CITY OF ALBUQUERQUE  
PLANNING DEPARTMENT  
DEVELOPMENT REVIEW BOARD

**Project# 1007051**

08DRB-70014 VACATION OF PUBLIC RIGHT-OF-WAY

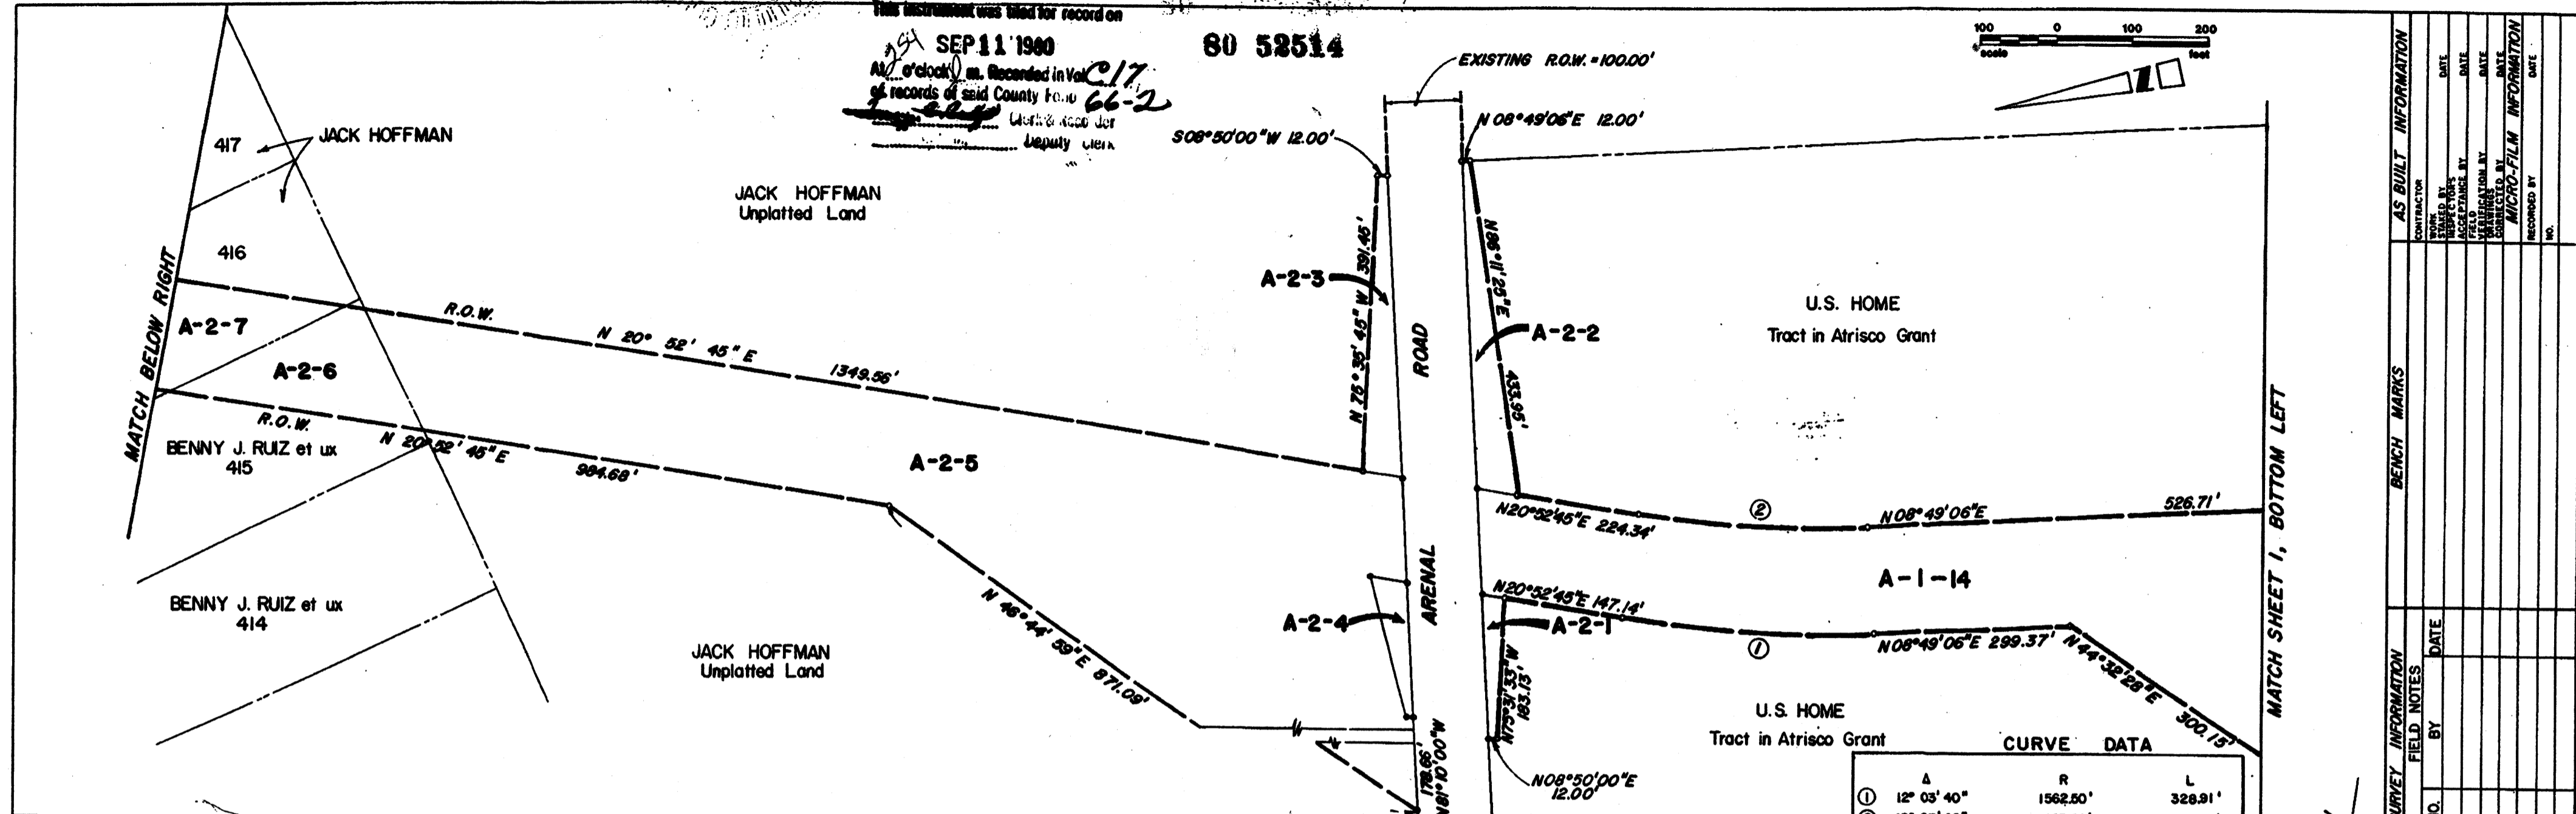
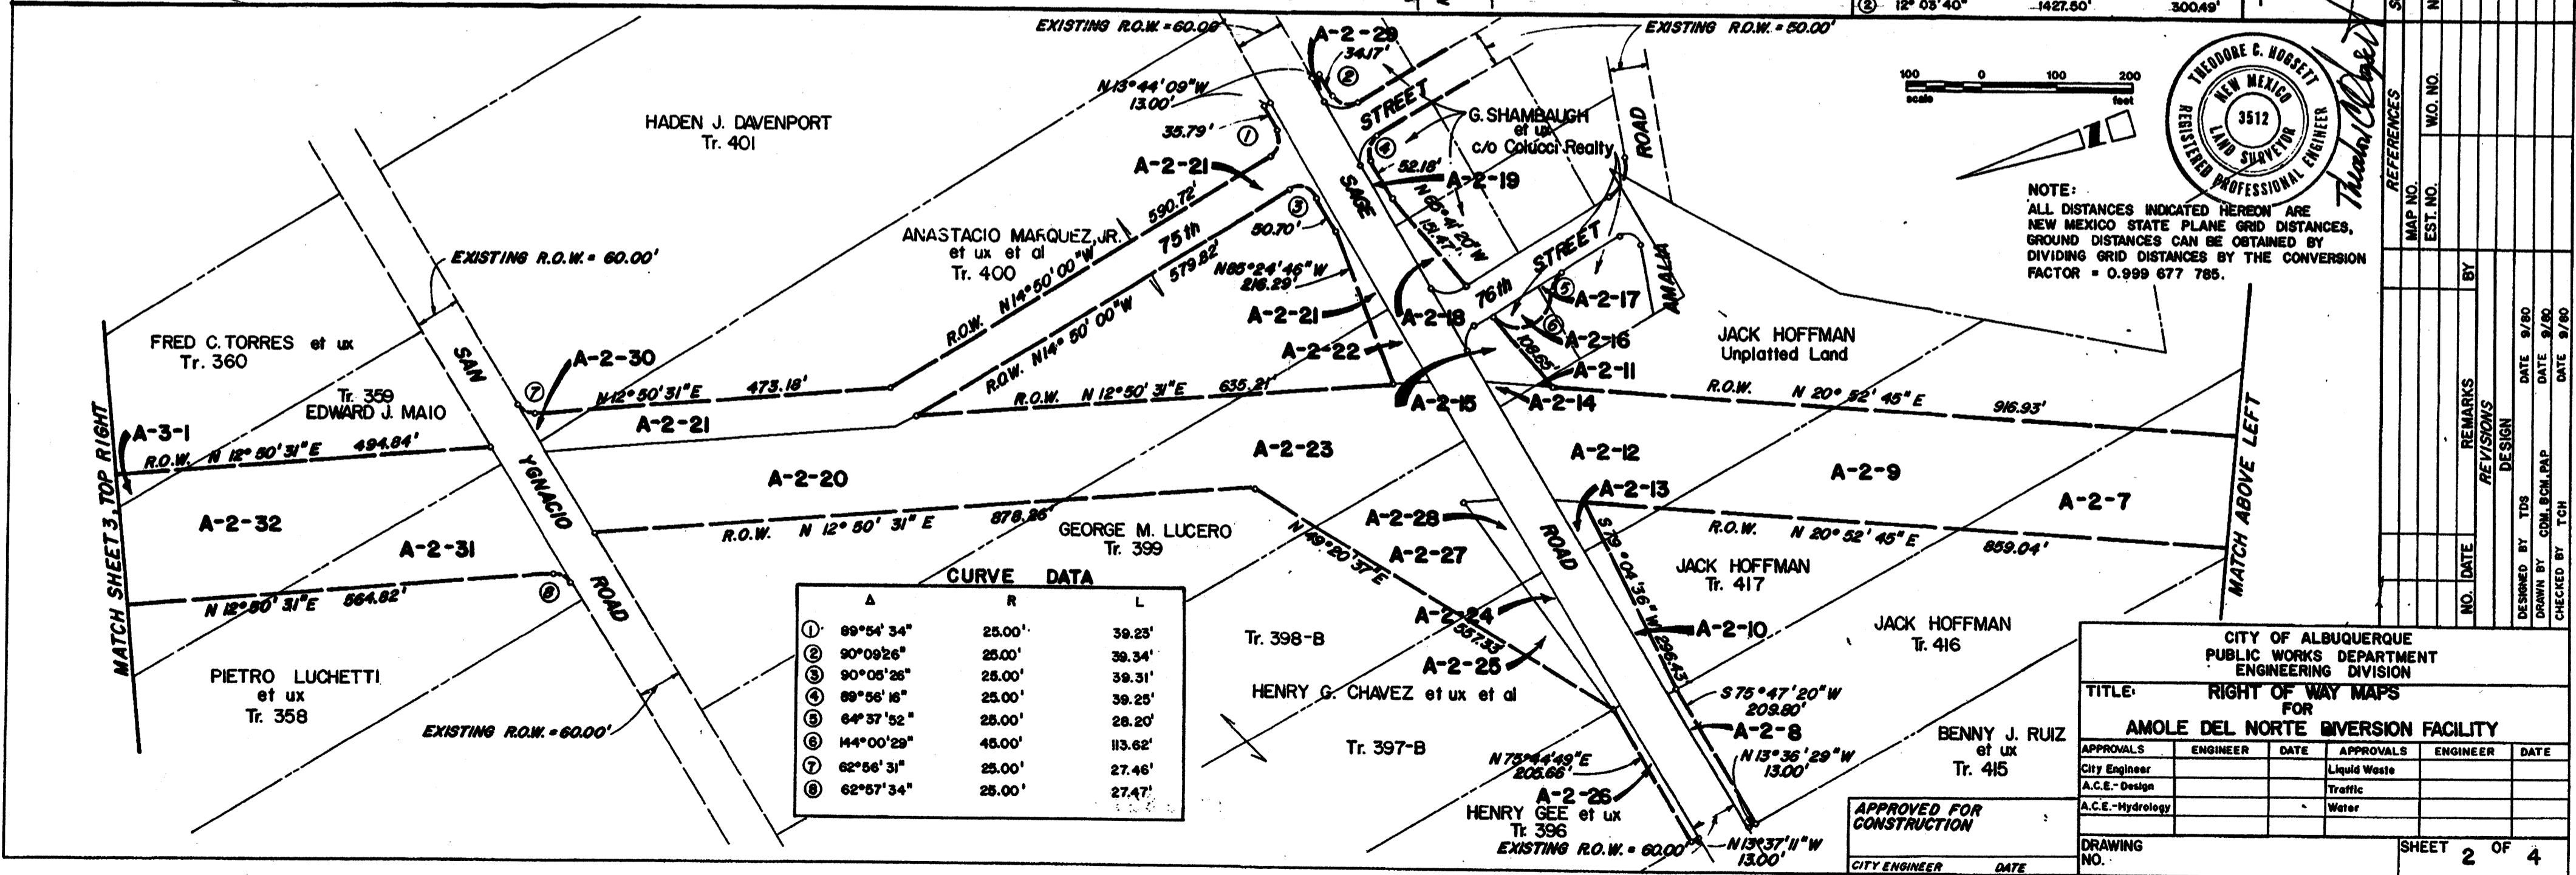
The Hydrology Section has no objection to the vacation request but will need **all** as-builts of record to determine how much R/W to retain. Infrastructure will be required for subsequent platting action.

City Hydrology does not have enough information to approve vacation. Provide as-built drawings of the channel and stormdrain in Sage in order to justify this request.

Additional information must be required to determine the necessary right of way for Sage Road. As-builts must be provided for this area.

At the March 12, 2008, Development Review Board meeting, the vacation was approved as shown on Exhibit B in the Planning file per section 14-14-7-2(A)(1) and (B) (1)(3) of the Subdivision Ordinance. A condition of final plat will be for all as-builts of record be submitted concurrently with the platting action.
